CONSULTANTS ADVICE

FOR 104-116 REGENT ST REDFERN NSW

PROJECT NAME:	104-116 Regent St Redfern NSW
Our Reference:	CA01- 046-2101
ATTENTION:	City of Sydney Council
FROM:	Ben Shojaei
Reference:	SSD-12618001 – Response to Council Comments – R/2020/17/A

This Consultants Advice has been prepared in relation to the Council's comments Ref: R/2020/17/A, File: 2022/059877.

2 Roof Level
Floor Plan 1 : 200

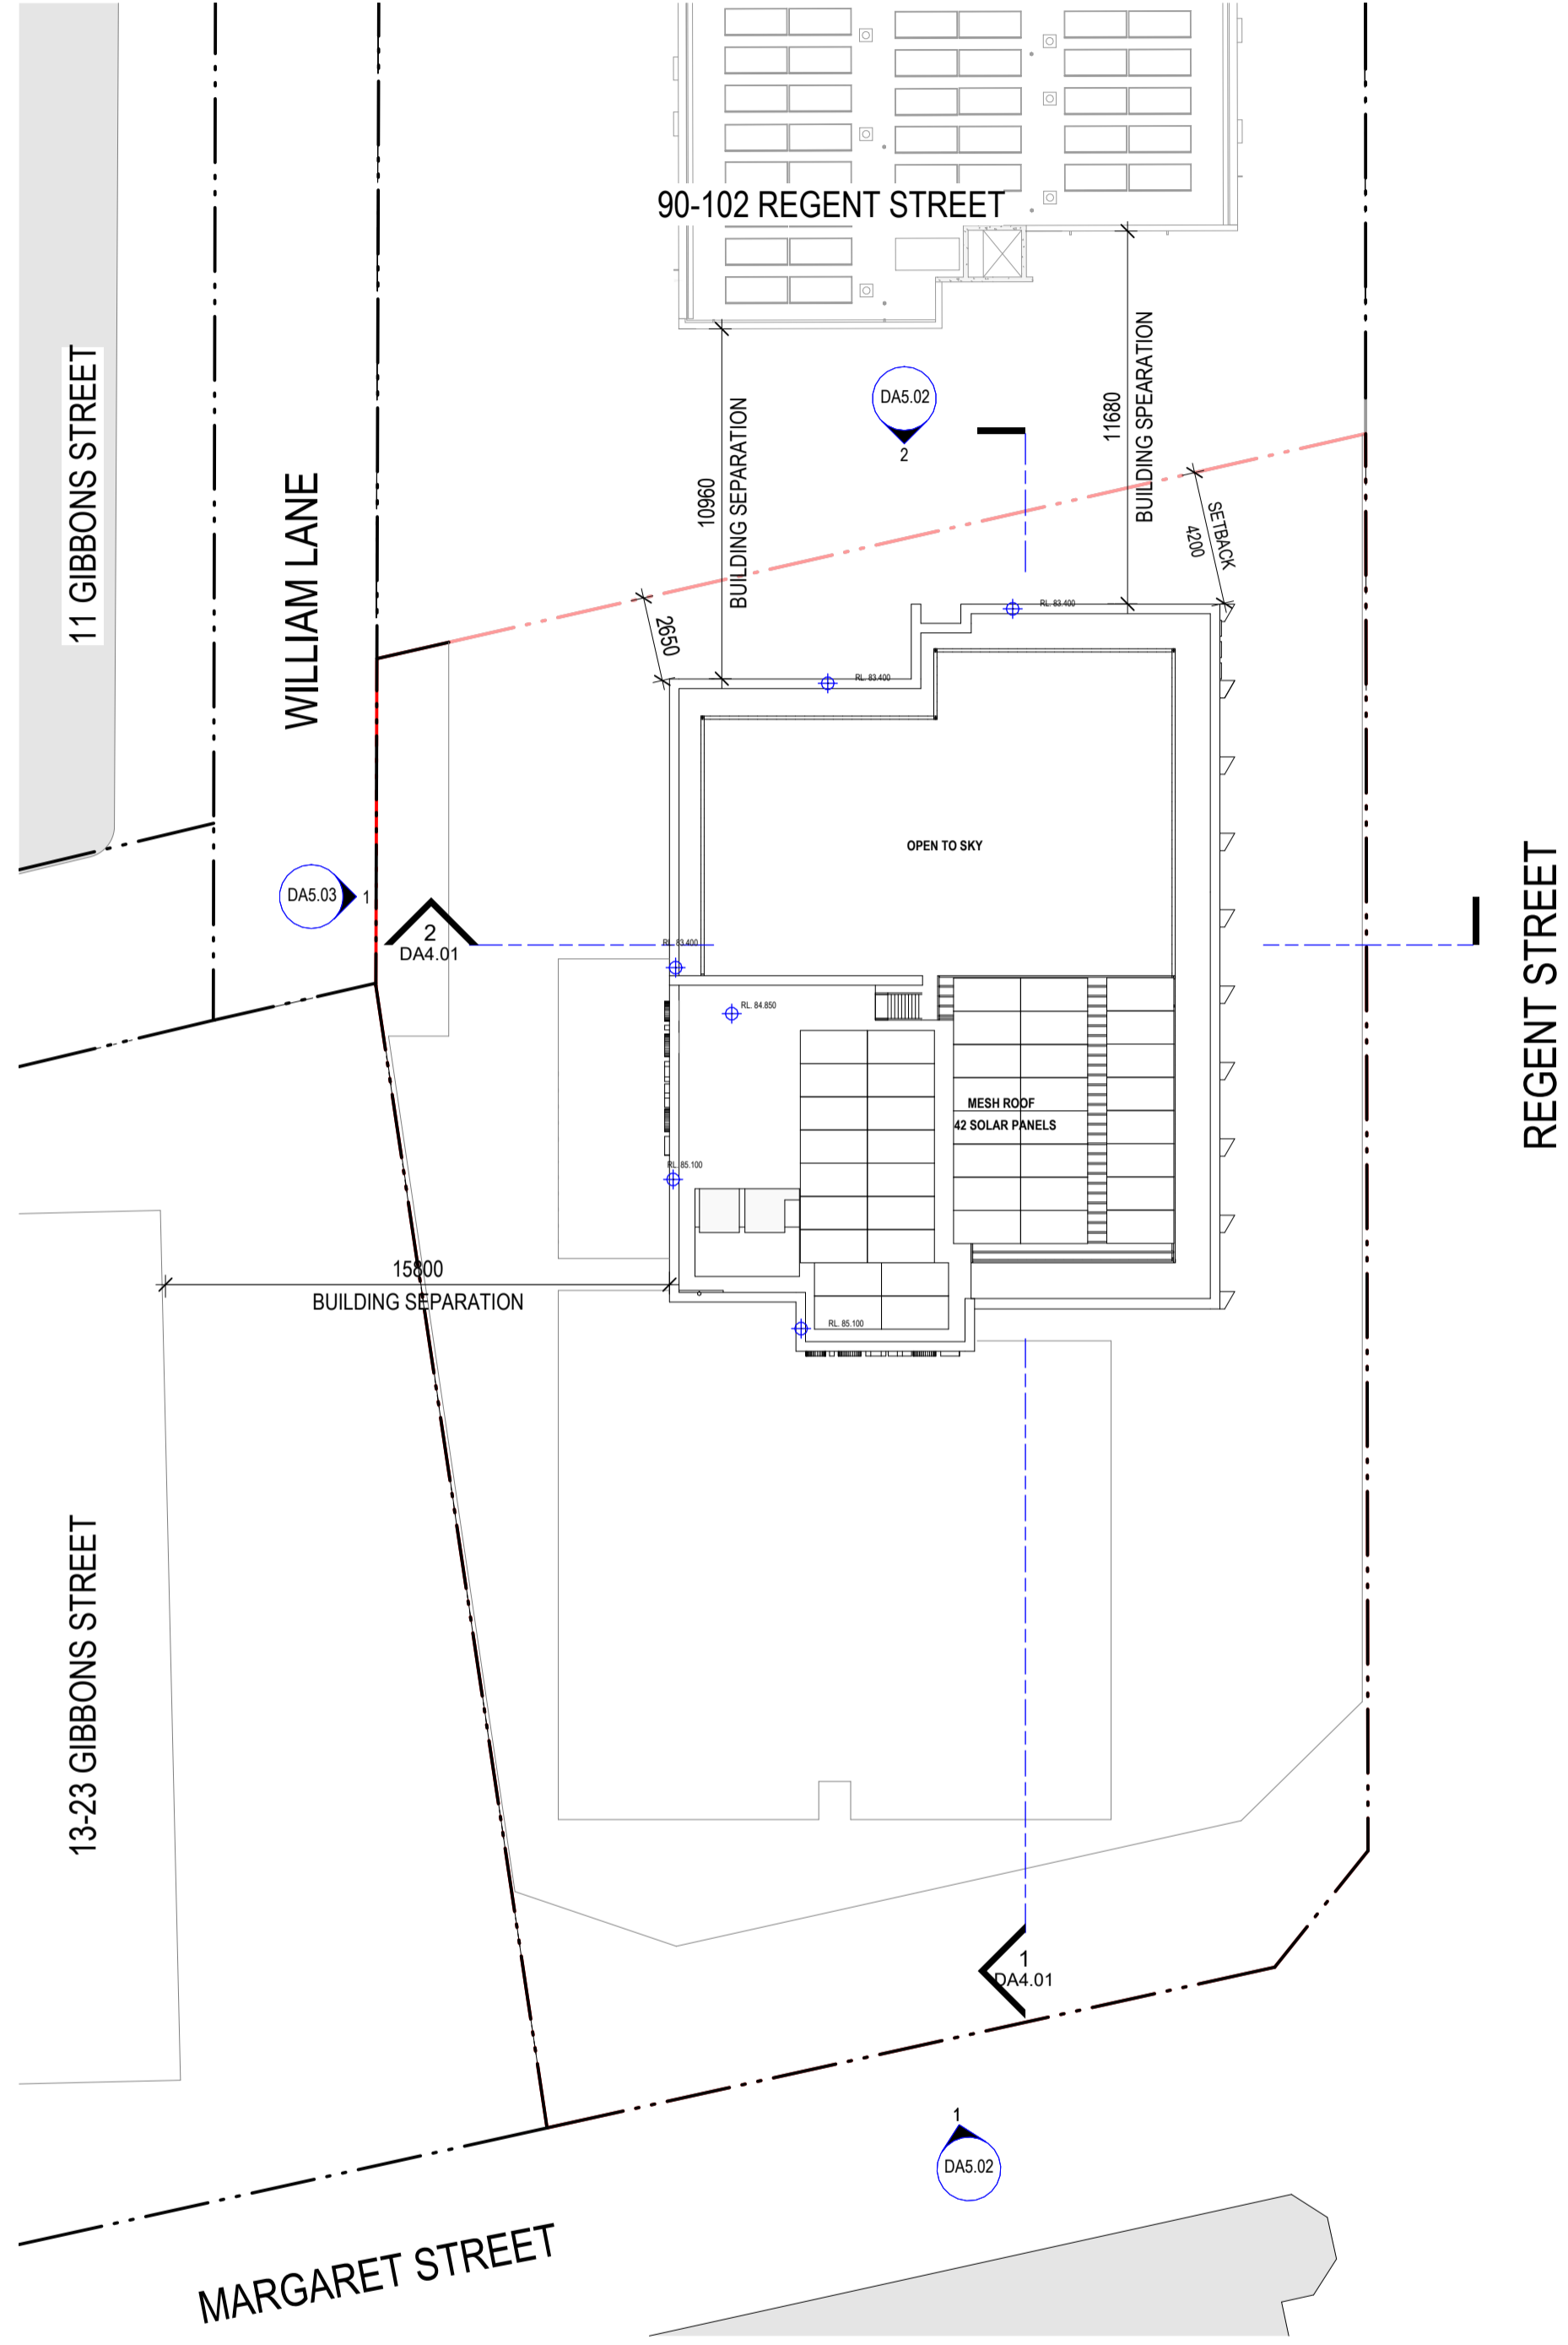
Further, there are discrepancies with the information submitted regarding the development's photovoltaic system. The submitted architectural plans indicate solar panels to be located on the roof. However, the BASIX requirements of 40-kilowatt peak capacity will require

approximately 280 square metres of roof area. This is confirmed in Vipac's Ventilation Report, that suggests 130 panels are needed. The Report also indicates that the development will house an on-site battery system to store renewable energy. The proposal must verify this intent and confirm that there is adequate roof area to accommodate the required solar panels. The system size in kilowatt peak is defined by BASIX and is not negotiable. Accordingly, the exact system sizing and configuration of the required solar panels must be confirmed and depicted in the architectural plans.

Based on your comments, the PV system size has now been reduced to 17.2 kW (38 panels x 455W), see snapshot below for the roof layout and the PV panel dimensions. For clarity, whilst the design team will keep the Solar PV system, the system will be removed from the BASIX certificate to demonstrate that the development will achieve BASIX compliance without the PV System.
